BT Street Hub Planning Applications April 2026

Ref	Link	Comment
2026/90571 2026/90572 Pavement o/s, Utilita, Ramsden Street, Huddersfield, HD1 2BQ	Planning application details Kirklees Council	<p>Support removal of the existing BT Telephone Booth.</p> <p>Object to the installation of a new BT Street Hub. The BT Street Hub would create an obstruction to the safe and free flow of pedestrian movements along the footway making it narrower and making it more difficult for pedestrians, wheelchair users, those with pushchairs and other vulnerable users, having a detrimental effect on their user experience.</p> <p>Pedestrian footfall is anticipated to increase on Ramsden Street due to significant regeneration schemes including Our Cultural Heart, along with public transport investment such as the refurbishment of Huddersfield Bus Station and the Transpennine Route Upgrade at the Huddersfield Railway Station. Ramsden Street will be a key pedestrian route between these locations.</p> <p>Any future improvement schemes to the footway would be affected by the BT Street Hub's power connections.</p>

Drawing Title  
**EXISTING AND PROPOSED ELEVATIONS**

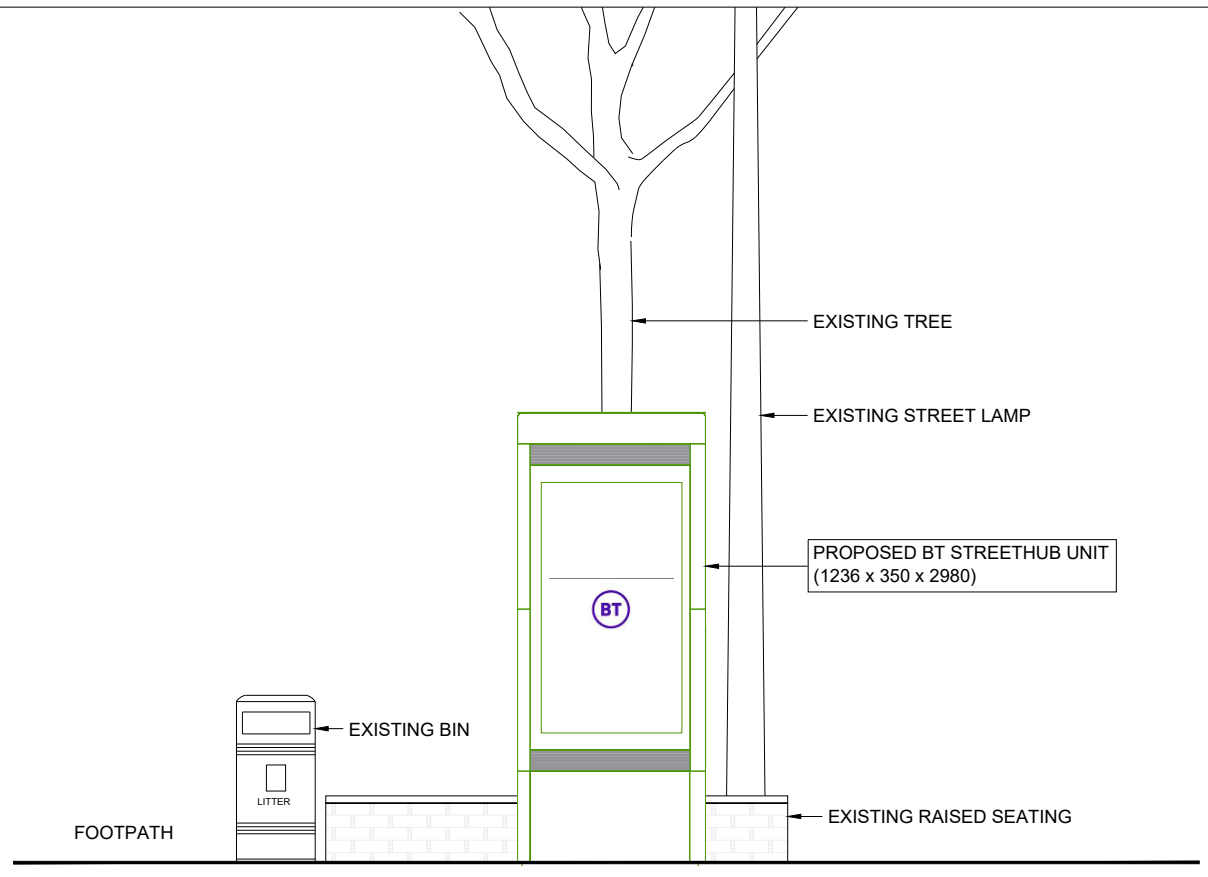
2026/90544 Adj 42 New Street, Huddersfield 2026/90545 Adj 42 New Street, Huddersfield	Planning application details Kirklees Council	<p>Support removal of the existing BT Telephone Booth.</p> <p>Object to the installation of a new BT Street Hub as there is already another Clear Channel screen in close proximity so a new BT Street Hub would add to street clutter and detract from the public realm aesthetics.</p>
2026/90539 Adj 106 New Street, Huddersfield 2026/90541 Adj 106 New Street, Huddersfield	Planning application details Kirklees Council	<p>Support removal of the existing BT Telephone Booth.</p> <p>Object to the installation of a new BT Street Hub that would add to street clutter.</p>
